Lighting Plan_V1.pdf Markup Summary

1. Cloud+
2. WireNut - Site Photometric-ES0.1

WIRENUT
HOME SERVICES
6365 E PLATTE AVE.
COLORADO SPRINGS, CO 80915
EL PASO COUNTY, COLORADO

1 SITE PHOTOMETRIC PLAN
ES0.1 SCALE: 1"=30'-0"

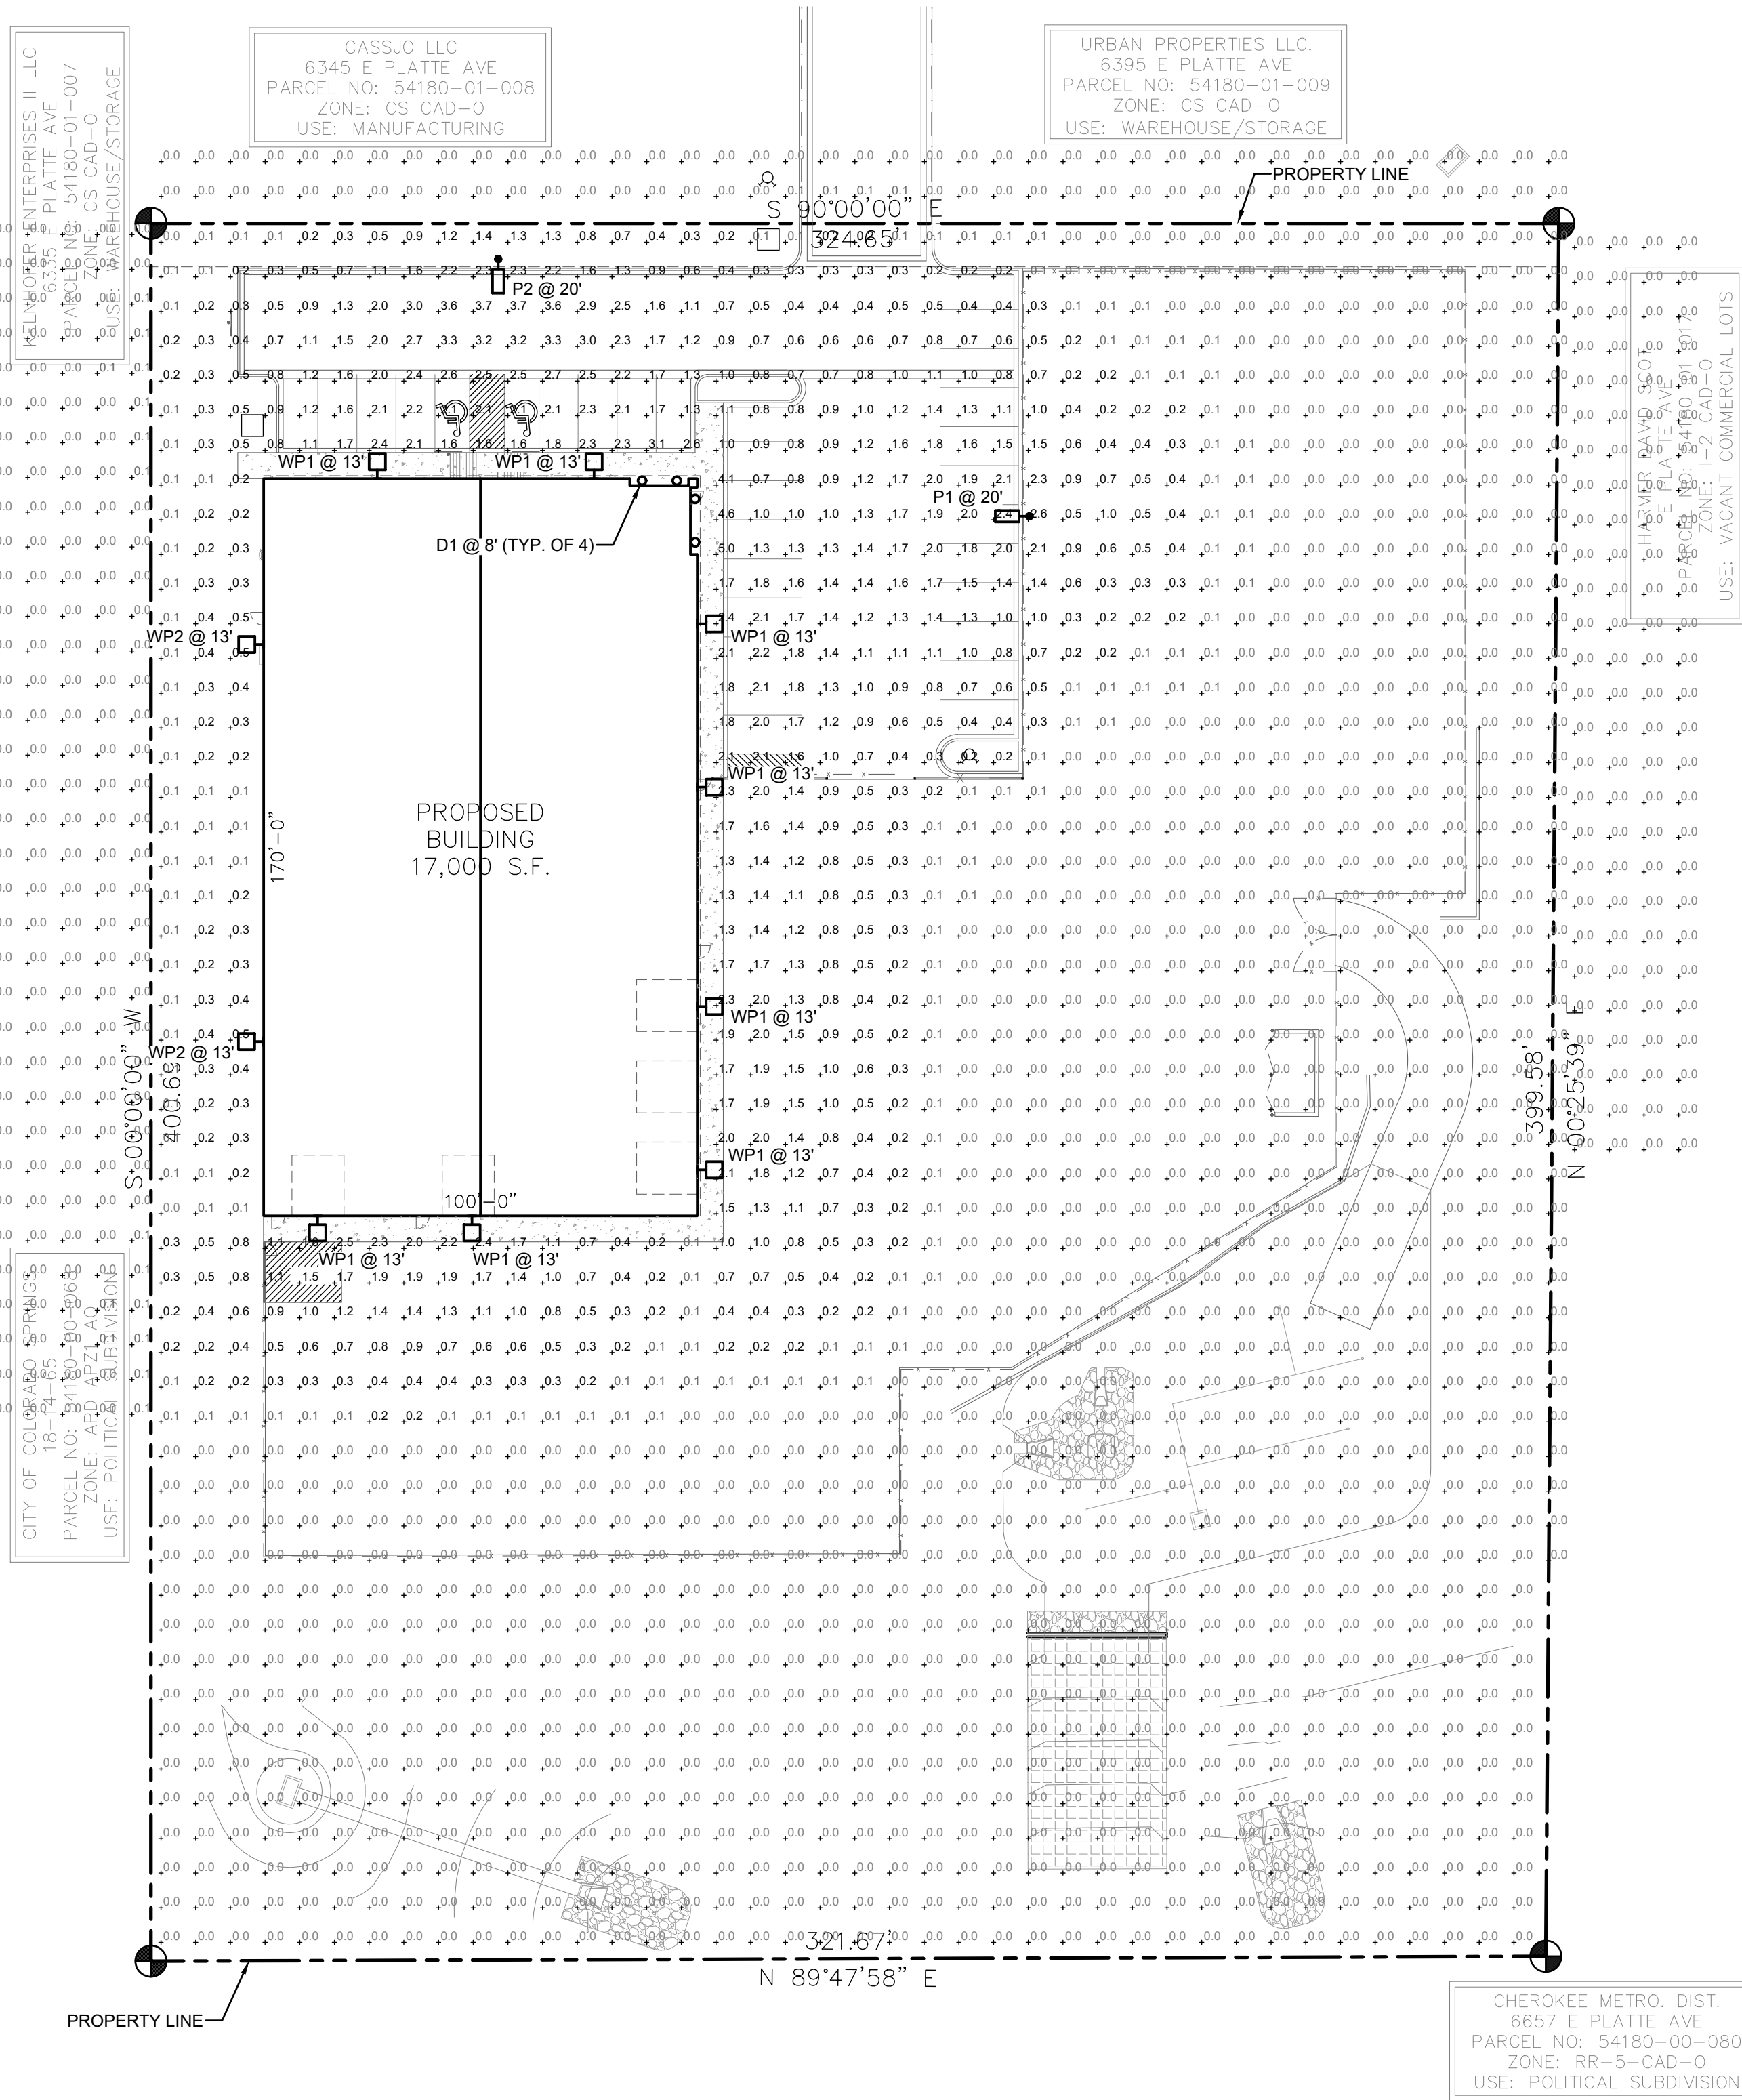
Subject: Cloud+
Page Label: [1] WireNut - Site Photometric-ES0.1
Author: Linda.Nguyen
Date: 7/12/2022 4:02:53 PM
Status:
Color: ■
Layer:
Space:

6.2.3 Lighting Height. No freestanding light fixtures shall be mounted higher than 15 feet, except parking lot light fixtures which shall be mounted no higher than 20 feet unless an alternative lighting proposal is approved in accordance with this Code.

6.2.3 Lighting
Height: No freestanding light fixtures shall be mounted higher than 15 feet, except parking lot light fixtures which shall be mounted no higher than 20 feet unless an alternative lighting proposal is approved in accordance with this Code.
